Re. New High School in Jerrabomberra SSD RFI
Our Ref. 5555

Reference is made to the response submissions from the Department of Planning, Industry and Environment (DPIE), - Queanbeyan - Palerang Regional Council and Transport for NSW (TfNSW) with respect to SSDA submission for the New High School in Jerrabomberra (Reference SSD – 24461956).

Table 1 DPIE RtS Letter

**SOIL AND WATER MANAGEMENT LEGEND**

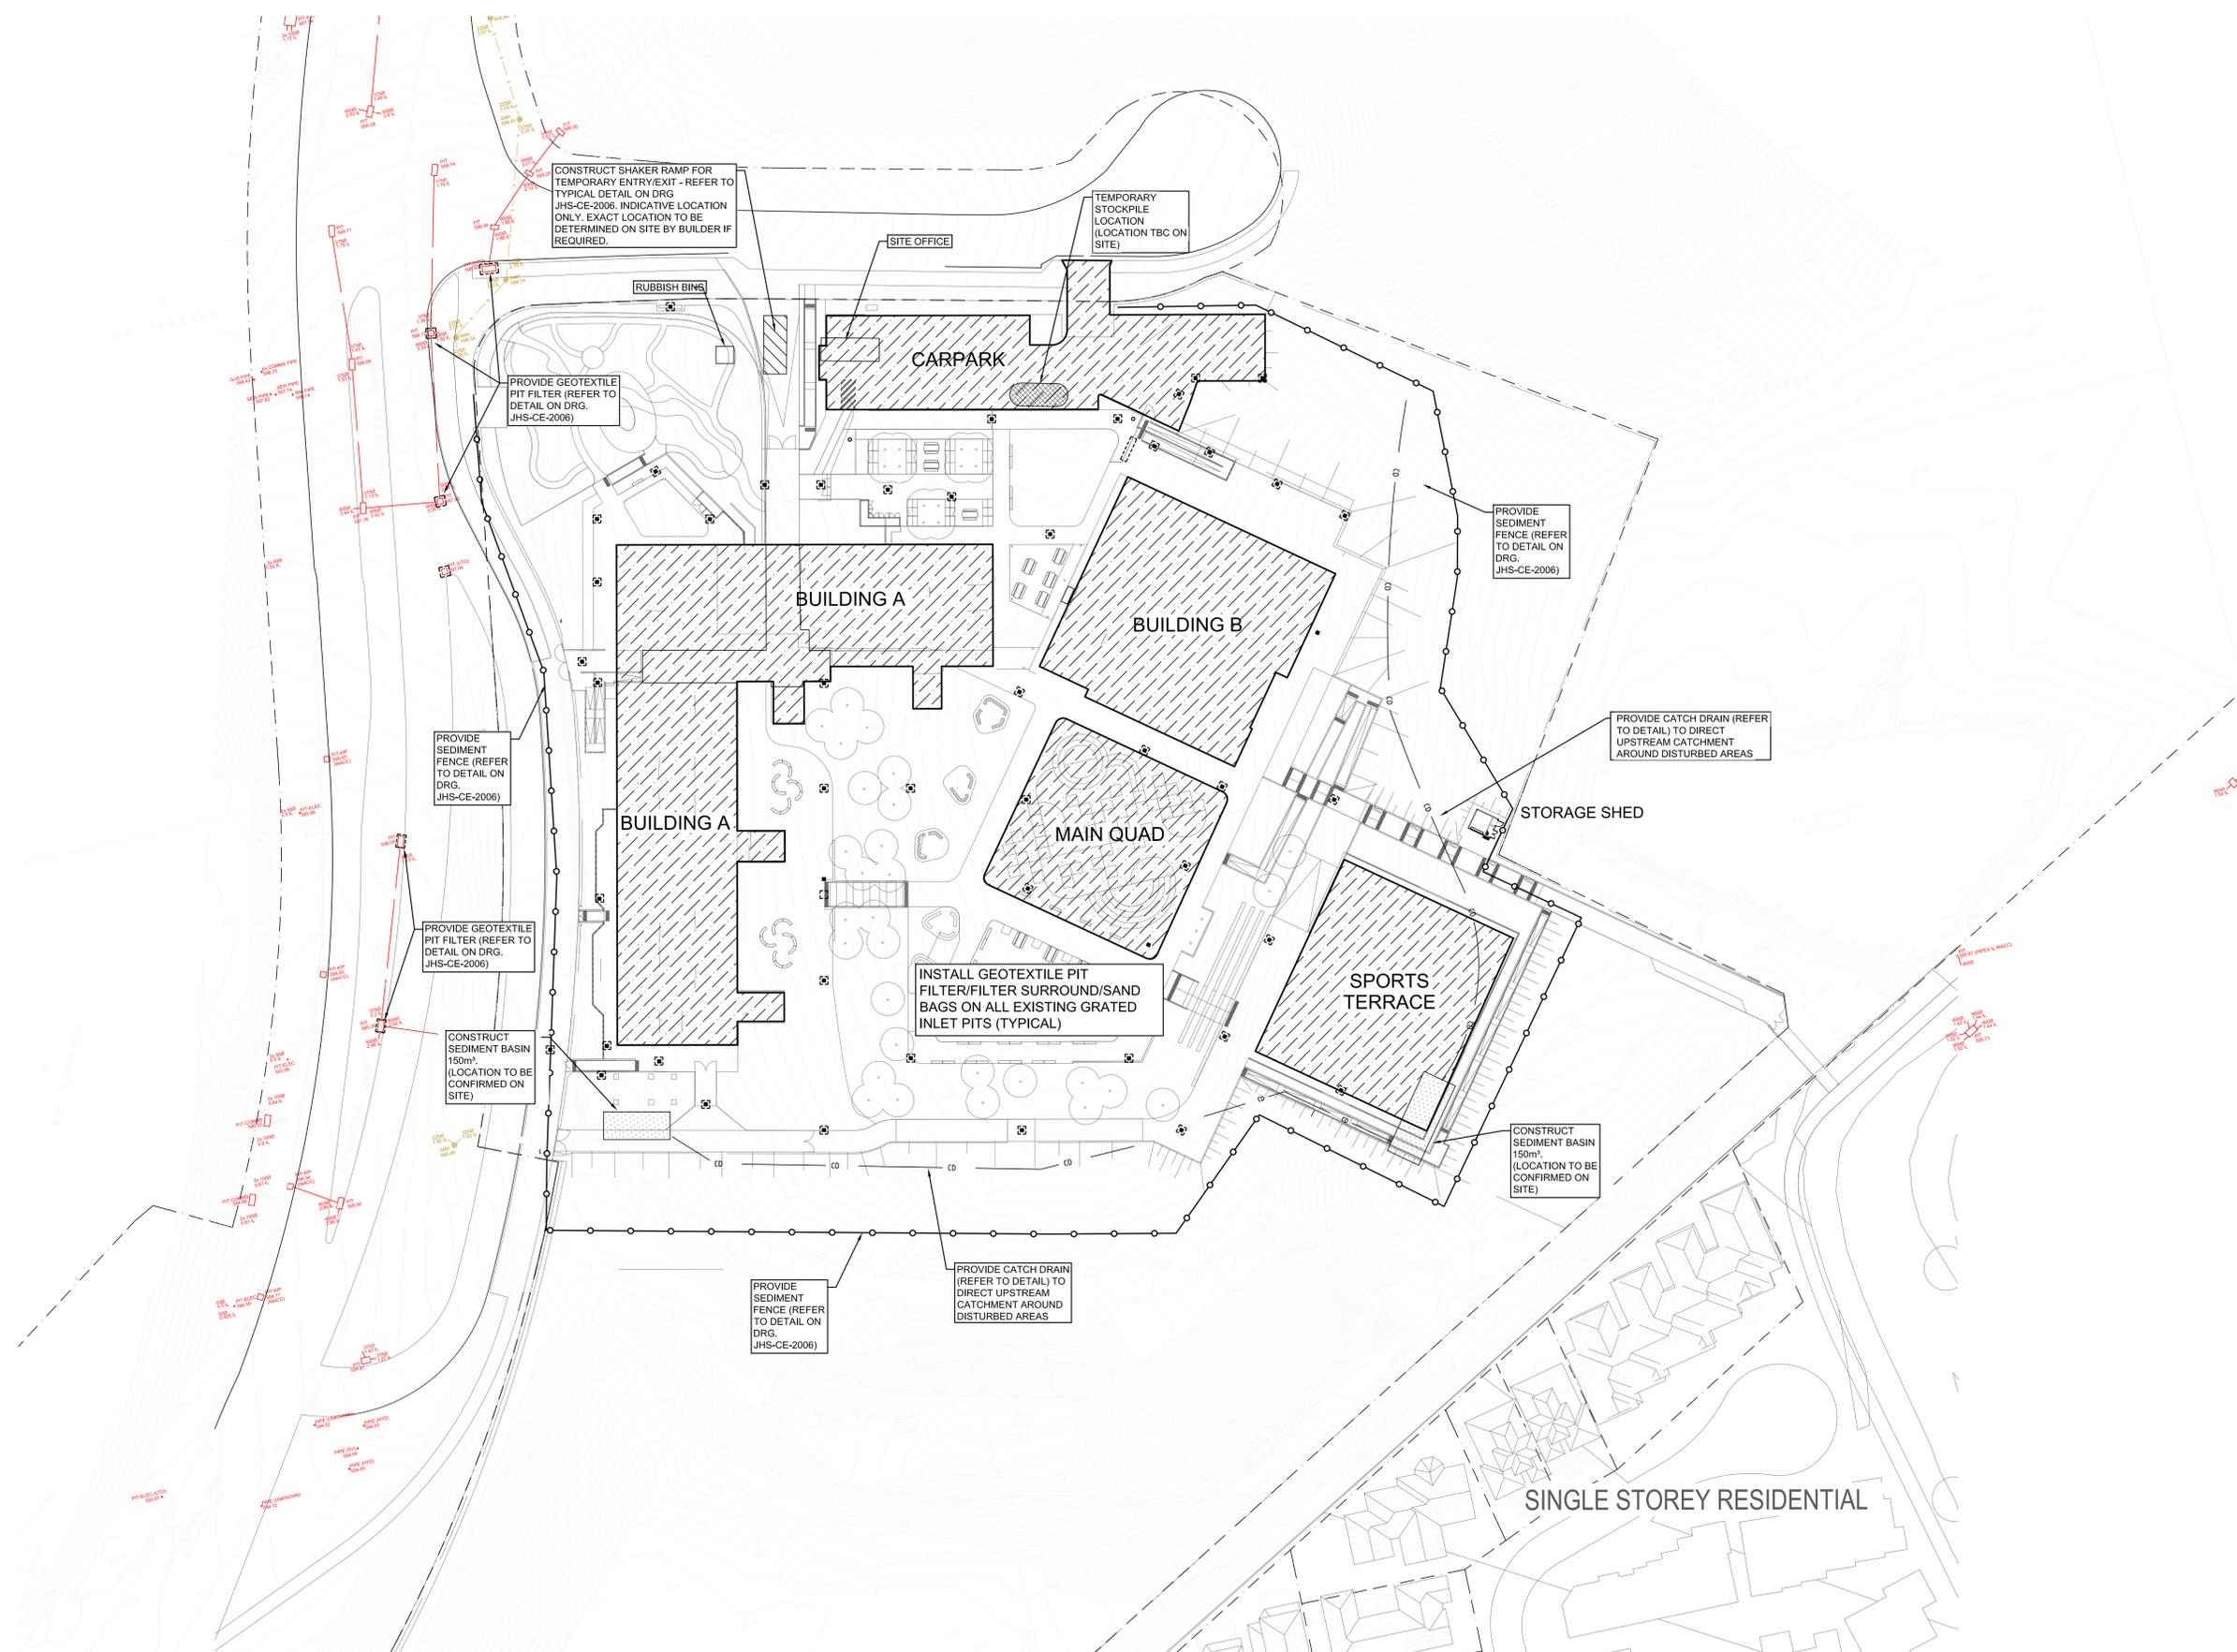
DPIE Submissions		
No.	DPIE RtS Letter	Response
5	<p>Water quality</p> <p>As per the EPA advice, further information must be provided to demonstrate the capacity, sizing, design rain event, catchment, and management of the sediment for the proposed temporary sediment basin.</p>	<p>A conceptual Soil & Water Management Plan (SWMP), in accordance with the “Blue Book”, providing preliminary details of the sediment control measures, has been prepared and is detailed on M+G drawings JHS-CE-2005 & 2006, attached to this response in Appendix A.</p> <p>A detailed SWMP containing detailed design of the Sediment Control, Erosion Control and Site Stabilisation practices, including staging of the earthworks and these practices, will be prepared by the earthwork contractor, subsequently reviewed and approved by Hindmarsh/M+G prior to civil works commencing.</p>
EPA – Appendix A	<p><u>Construction</u></p> <p>The receiving waterway for the proposal is the Jerrabomberra Creek, which ultimately flows into Lake Burley Griffin which forms part of the high conservation value Murrumbidgee Catchment. The EIS does not consider the NSW Water Quality Objectives (WQOs) for the receiving waters. The WQOs and the Australian and New Zealand Guidelines for Fresh and Marine Water Quality provide the general framework to assess the potential impact of discharge on the environmental values of the receiving waters.</p> <p>The EPA recommends consideration of the receiving environment and the relevant WQOs in relation to the proposal and how any discharge from the site will meet or improve the environmental values of the receiving waters.</p>	<p>To ensure that the receiving waters (Jerrabomberra Creek) are not polluted or significantly affected in terms of Water Quality during construction works for the proposed development, all civil works are to be undertaken in accordance with NSW Government Requirements <i>“Managing Urban Stormwater: Soils and Construction”</i> referred to as the “Blue Book”.</p> <p>The stormwater drainage system for the proposed development has been designed to incorporate Water Sensitive Urban Design (WSUD) elements; bioretention swale/basin and stormwater treatment system in the On-Site Detention (OSD) tank, to reduce the pollution load of the receiving waters to levels to acceptable Water Quality levels. MUSIC modelling of the pollutant loads has been undertaken to design these WSUD elements.</p>

EPA – Appendix A	<p><u>Construction</u></p> <p>The EIS identifies that, prior to any earthworks commencing onsite, soil and water management control measures that comply with the Managing Urban Stormwater – Soils and Construction will need to be</p>	<p>A conceptual Soil & Water Management Plan (SWMP), in accordance with the “Blue Book” has been prepared and is detailed on M+G drawings JHS-CE-2005 & 2006, attached to this response in the Appendix A.</p>

<p>in place. The EPA acknowledges that a range of sediment and erosion control measures are discussed in the EIS, including the installation of a temporary sediment basin to capture site runoff. Details on the capacity, sizing, design rain event, catchment, and management of the sediment basin has not been provided. The EPA recommends further information to demonstrate the capacity, sizing, design rain event, catchment and management of the sediment be provided.</p> <p>The EPA recommends that a detailed Sediment and Erosion Control Management Plan is developed for the proposed construction prior to the commencement of works.</p>	<p>A detailed SWMP containing detailed design of the Sediment Control, Erosion Control and Site Stabilisation practices, including staging of the earthworks and these practices, will be prepared by the earthwork contractor and reviewed and approved by Hindmarsh/M+G prior to civil works commencing.</p> <p>This plan will include monitoring provisions that will allow the SWMP to be changed/modified during the works to ensure that the required Water Quality Objective are achieved during the construction stage.</p>
